Application for a non-material amendment following a grant of planning permission.

Number	75
Suffix	
Property name	
Address line 1	Highfield Road
Address line 2	
Address line 3	
Town/city	Bognor Regis
Postcode	PO22 8PD
Description of site location must be completed if postcode is not known:	
Easting (x)	493703
Northing (y)	100082

Reference number:	BR129/19/PL
Date of decision	08/10/2019

Revised Window positions and addition of New Window (to be frosted) to South Elevation.

South Elevation (Proposed) @ 1:100

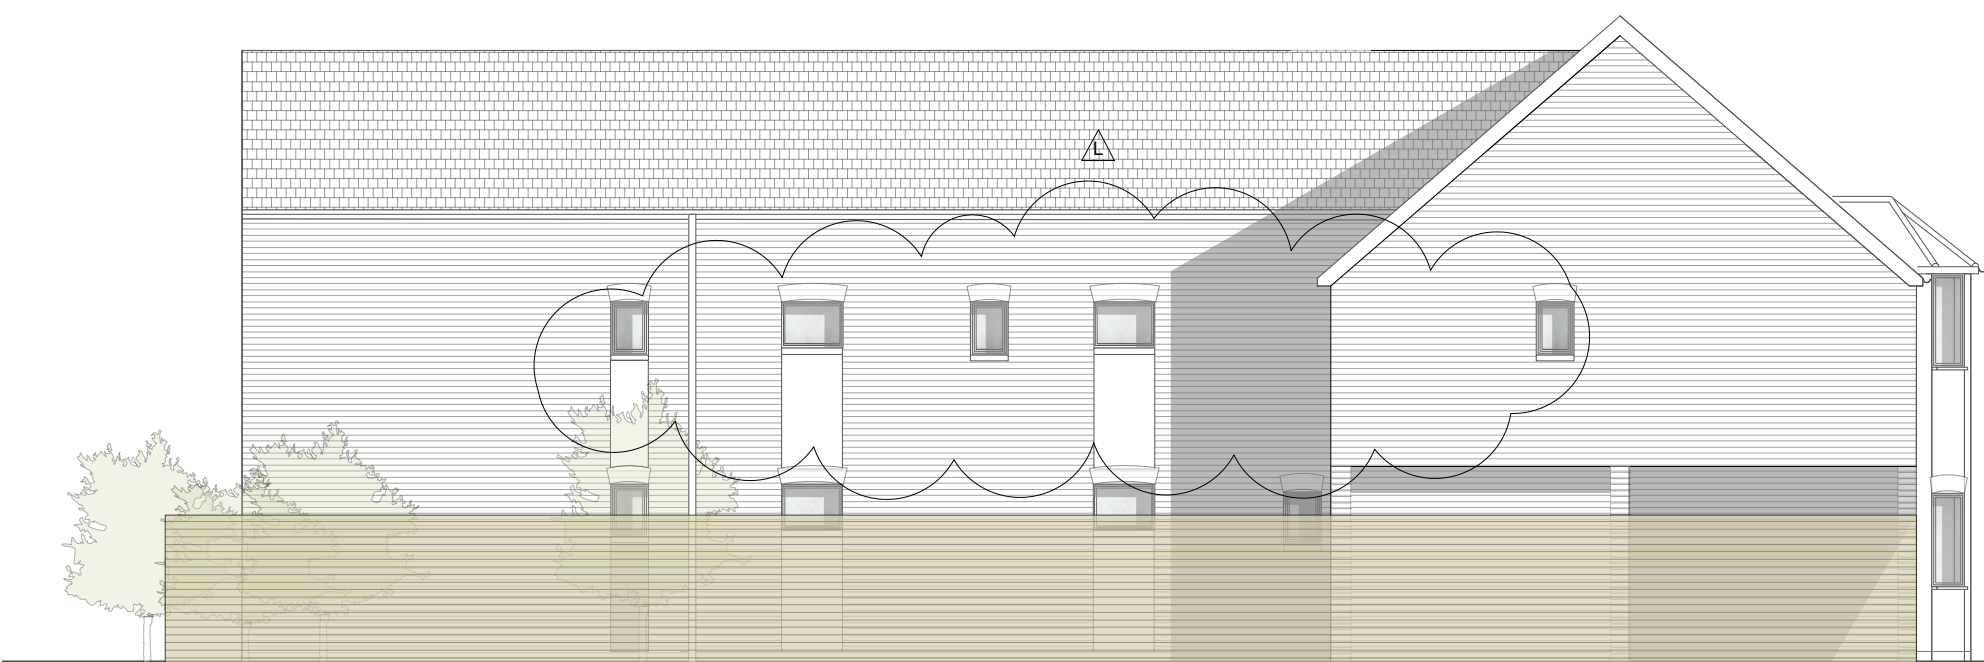
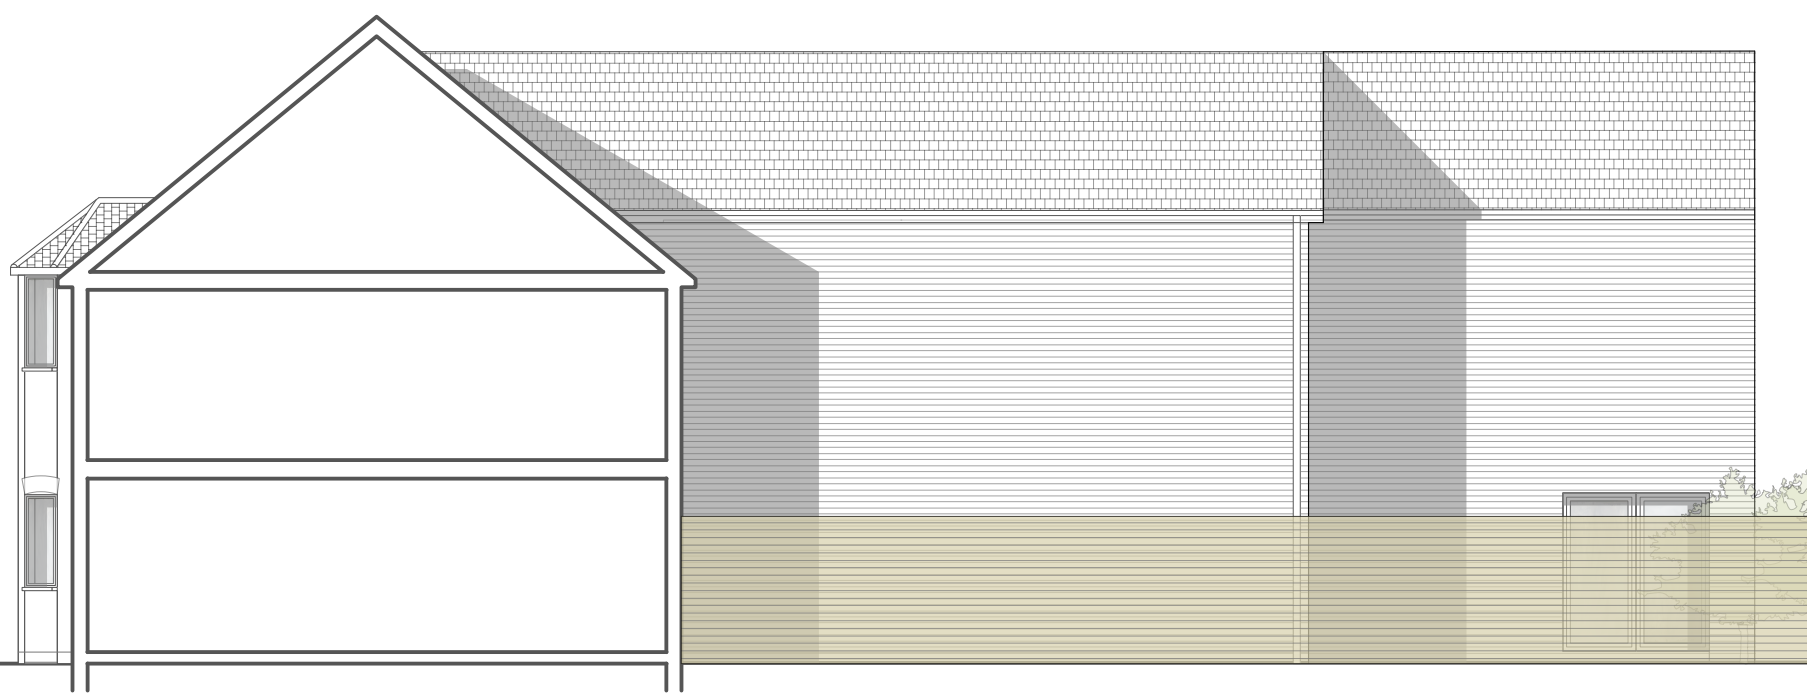
Additional Window proposed to South Elevation to be frosted glass to proposed en-suite bathroom.
Reconfigure position of Windows to south elevation from approved application

Revised First Floor Plan layout for improved internal layout
